Subject: RE: Attached letter from Kirklees Council regarding application number 2023/93726 at location 40, Underbank End Road, Holmfirth, HD9 1ES

Bridges & Structures Manager
Structures Section
Highways and Streetscene
Kirklees Council

Site Plan as Proposed

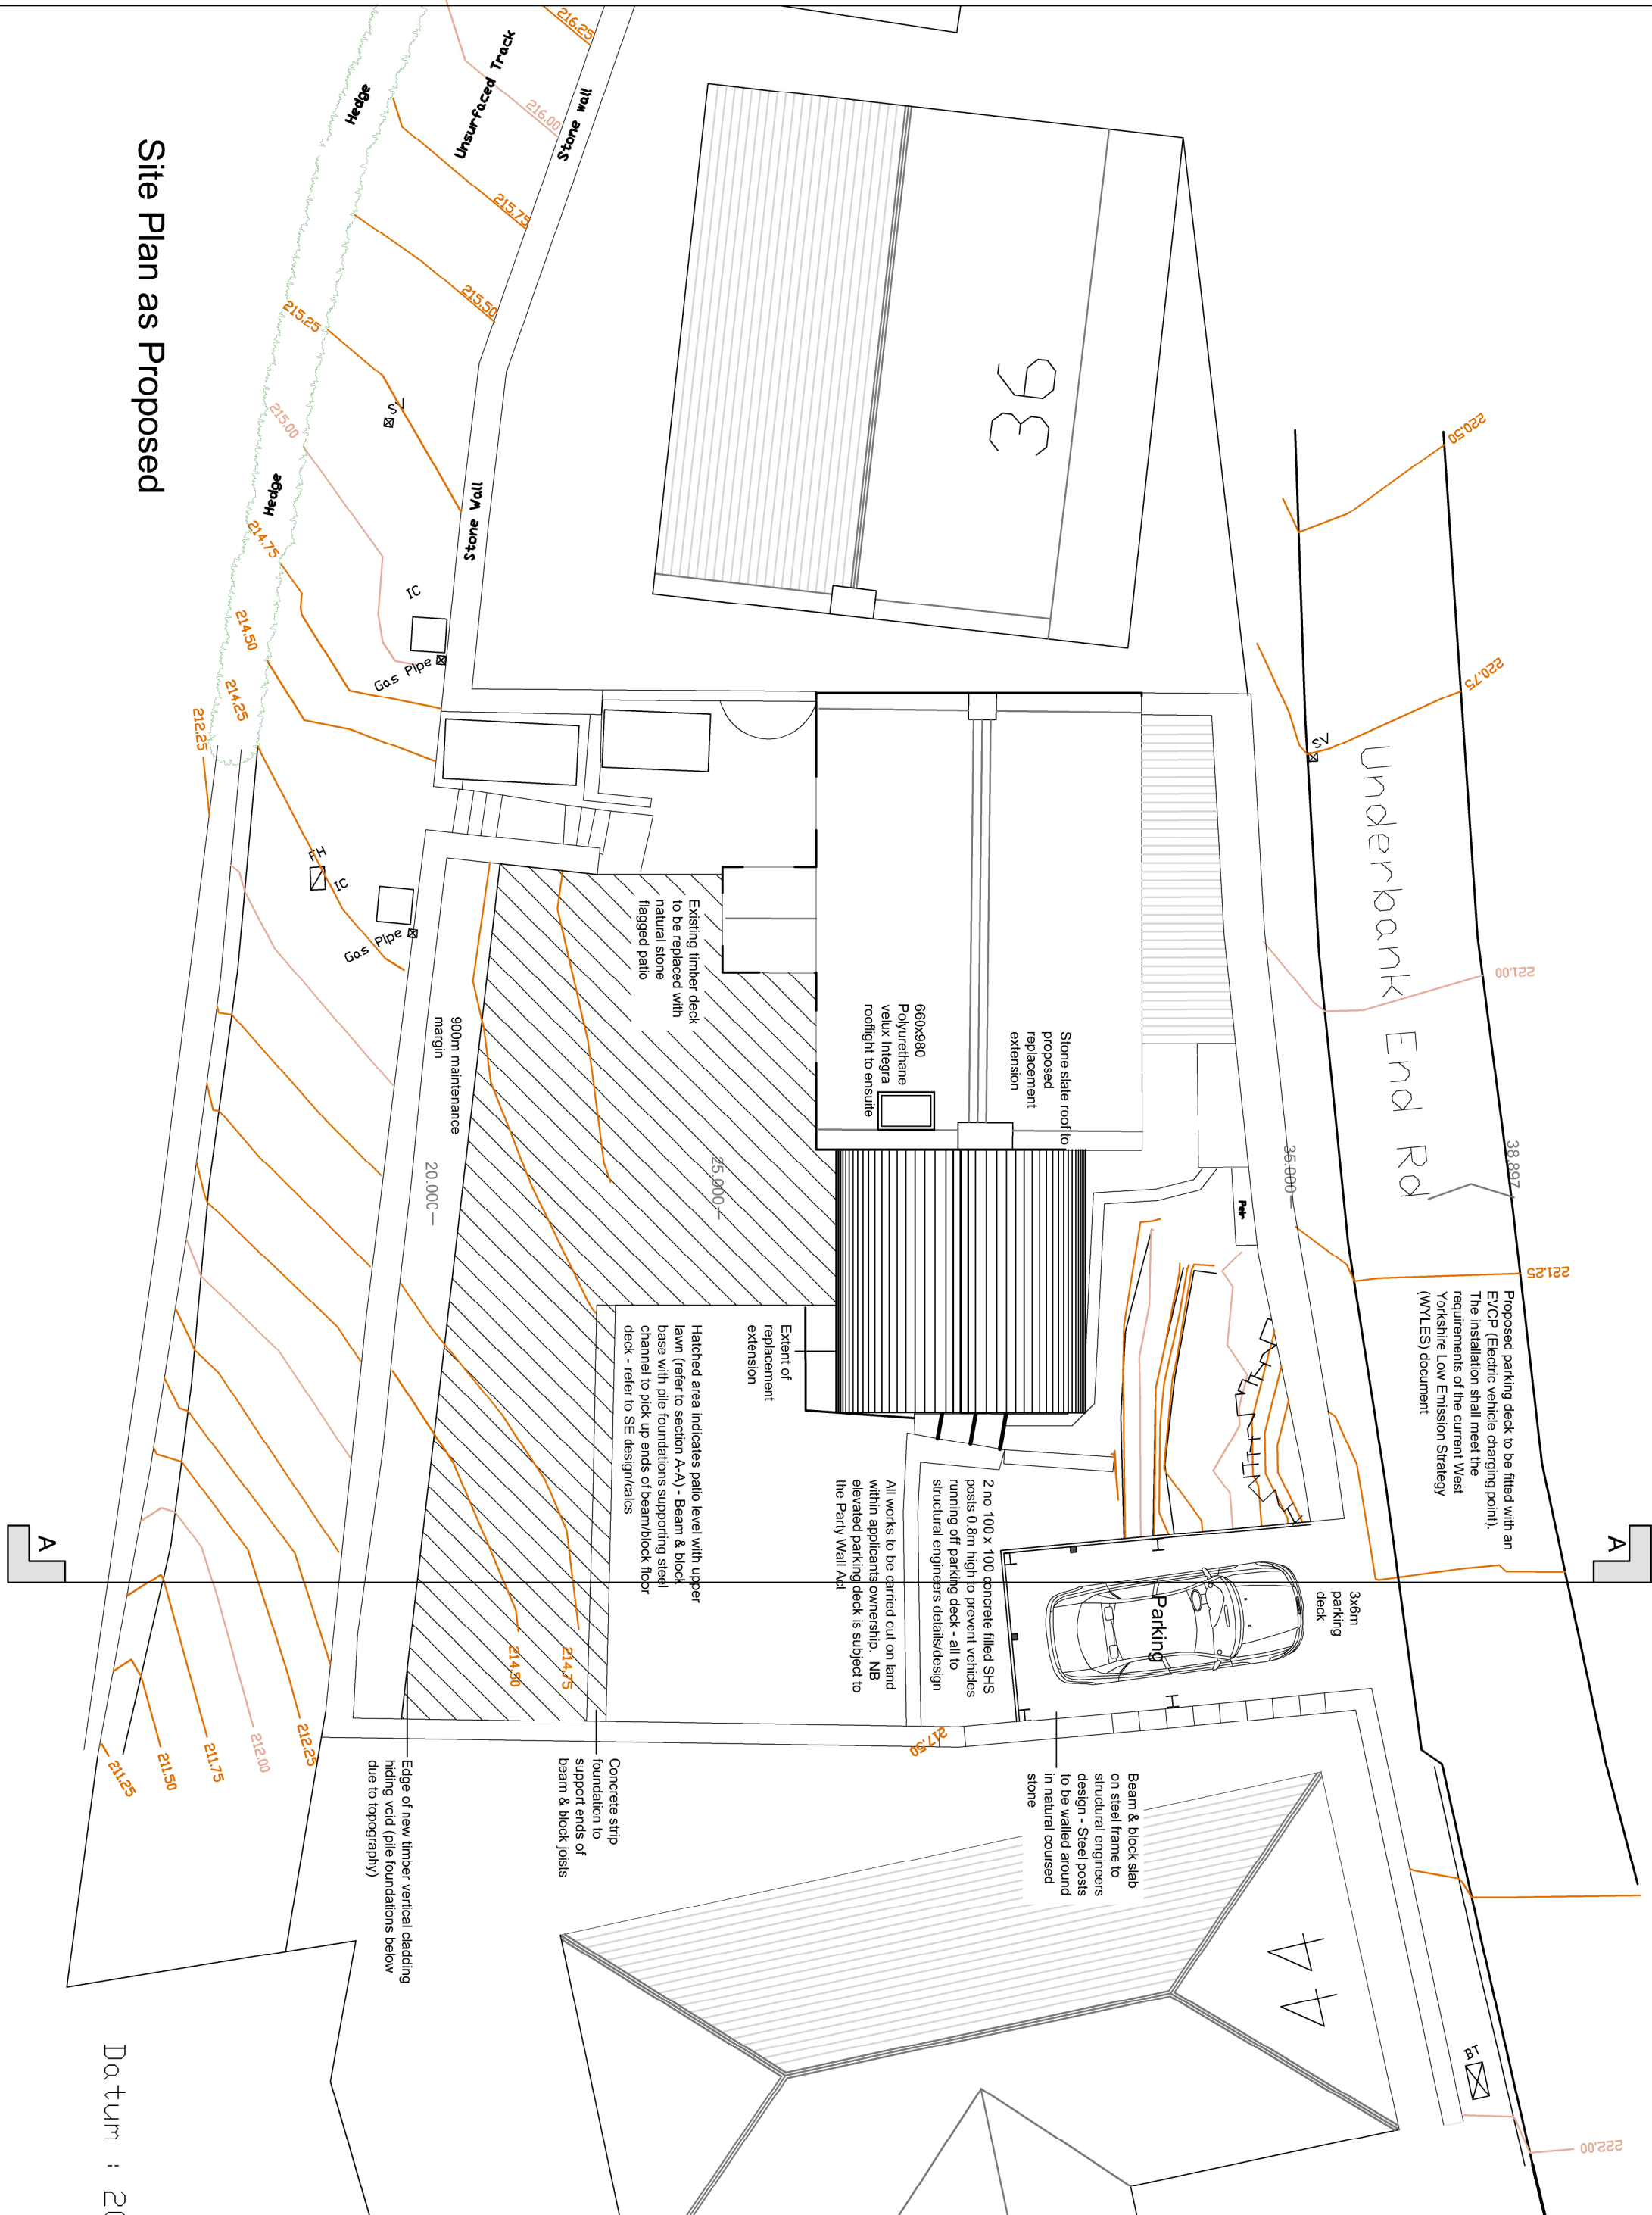
- 1) Before the development commences, the design of proposed retaining walls adjacent to the existing highway including any modification to the existing wall supporting Underbank End Road shall be submitted (via the submission of AIPs) and approved by the Highway Authority in writing. The approved scheme shall be implemented prior to the commencement of the proposed development and thereafter retained during the life of the development.
